SF-18-027

TimberRidge Estates

# Markup Summary

PCD FILE NO: SF-18-27

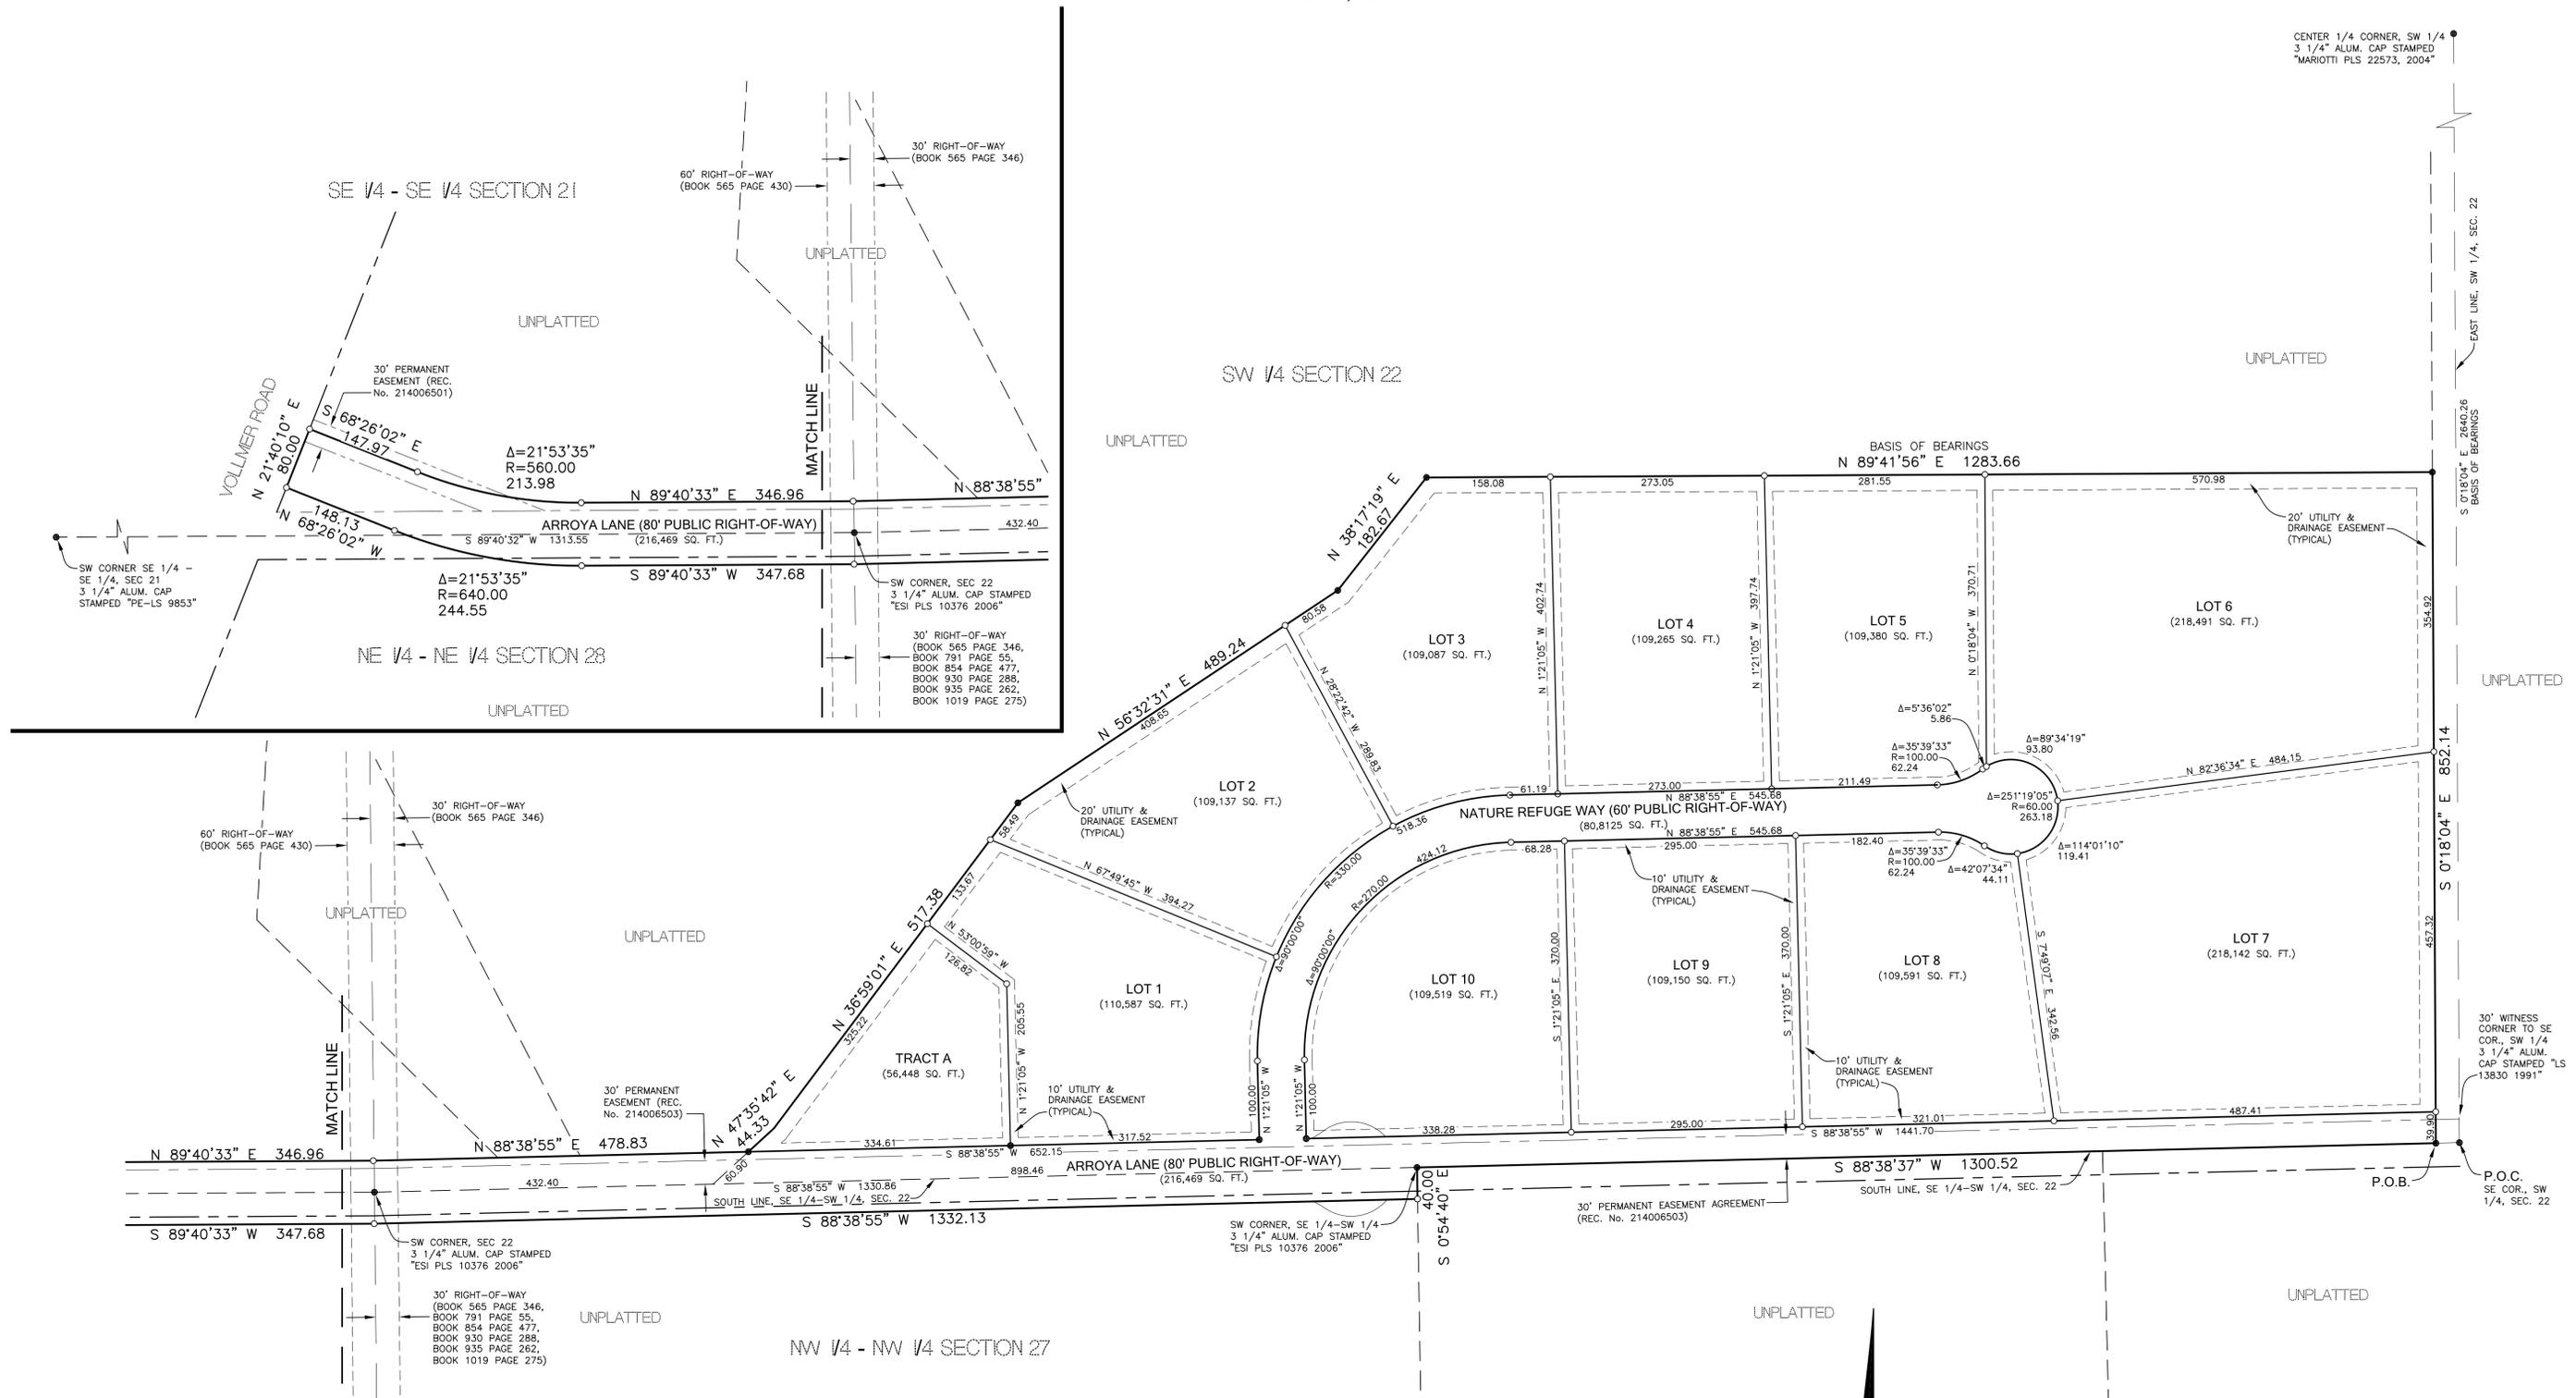
Provide an exhibit for the offsite easements and have the owner, M. Turner, providing the easement sign the document to be recorded. This is a plat not an off site easement.

Show Cul-De-Sac bulb, r-o-w & easements.

Call out Nature Refuge Way 60' Public Right-of-Way.

Call out Arroya Lane as 80' Public Right-Of-Way.

Call out drainage easements.
